Modification of Approval

Restoration and refurbishment of the Sirius Site (SSD_10384_Mod 3)

2-60 Cumberland Street, the Rocks

August 29, 2022

AR-DA-C-10-00

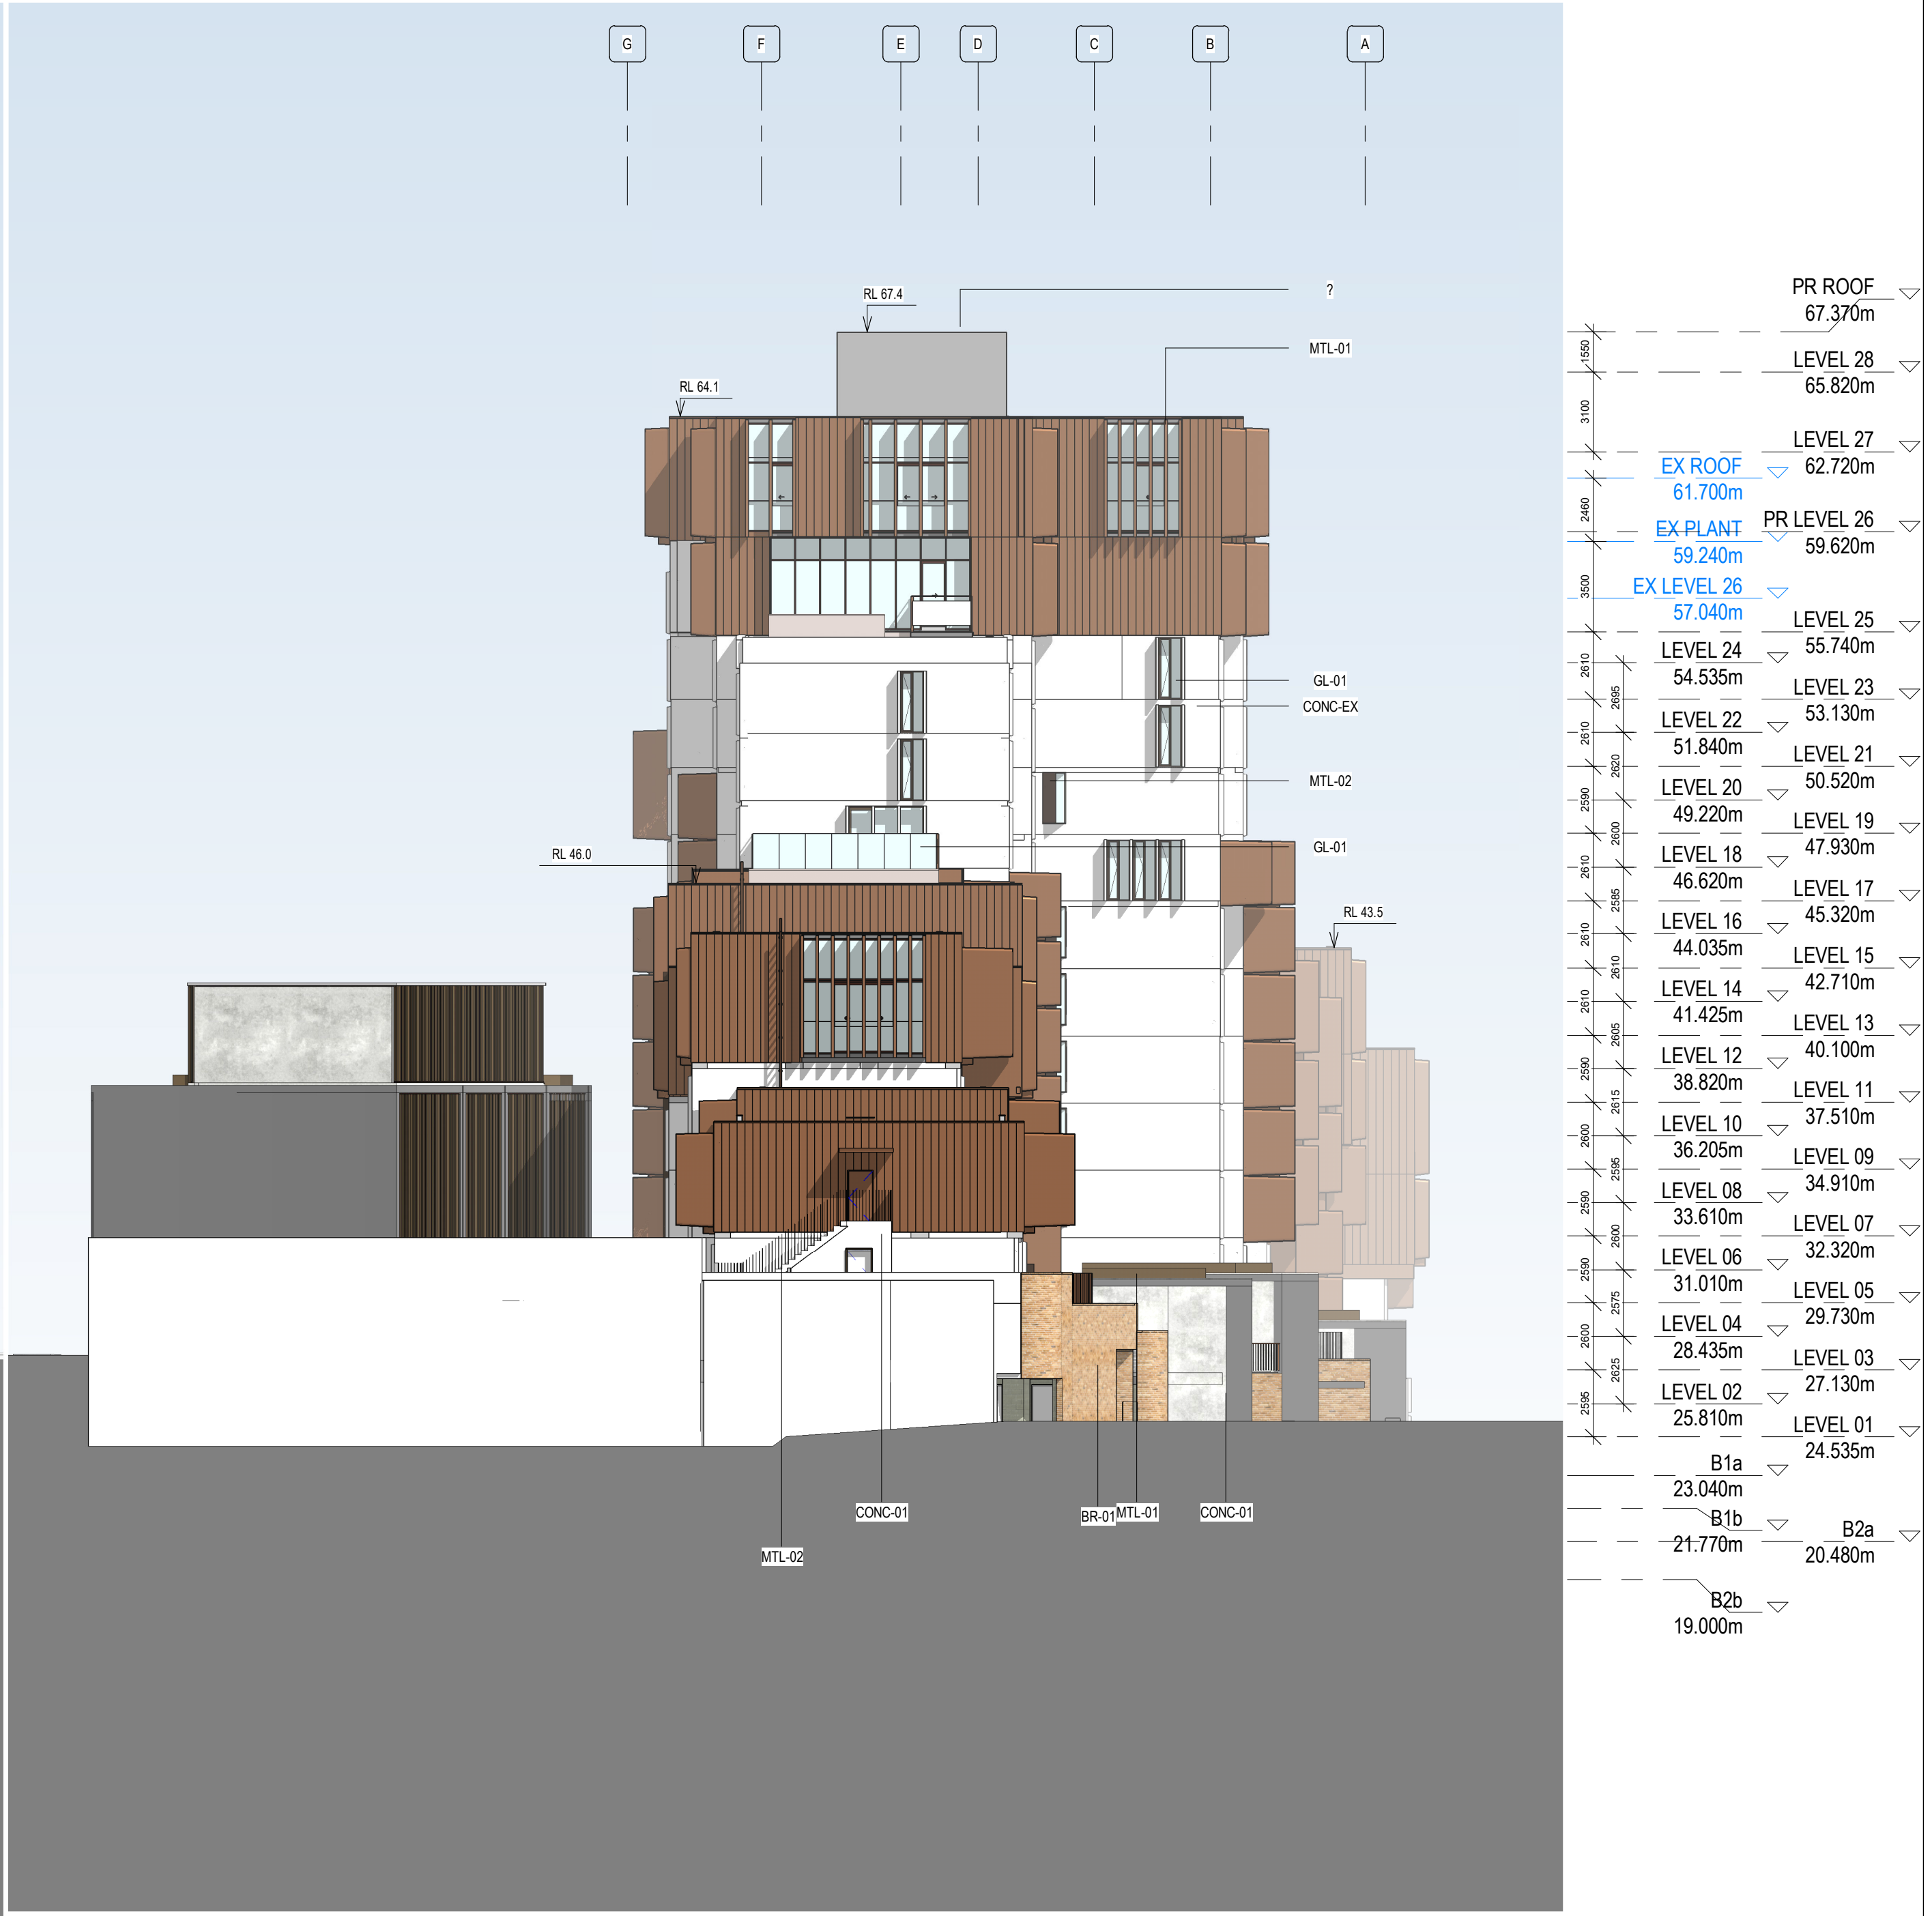
- Reduce the width from 3m which extended to the face of the kerb to 1.78m to avoid any conflicts with vehicles on Cumberland Street and for greater consistency with the Sydney DCP which requires awnings to be setback 1m from the face of the kerb
- Increase the height from 2.50m to 3.20m to ensure consistency with the Sydney DCP which requires awnings to be between 3.2m and 4.2m above the footpath.
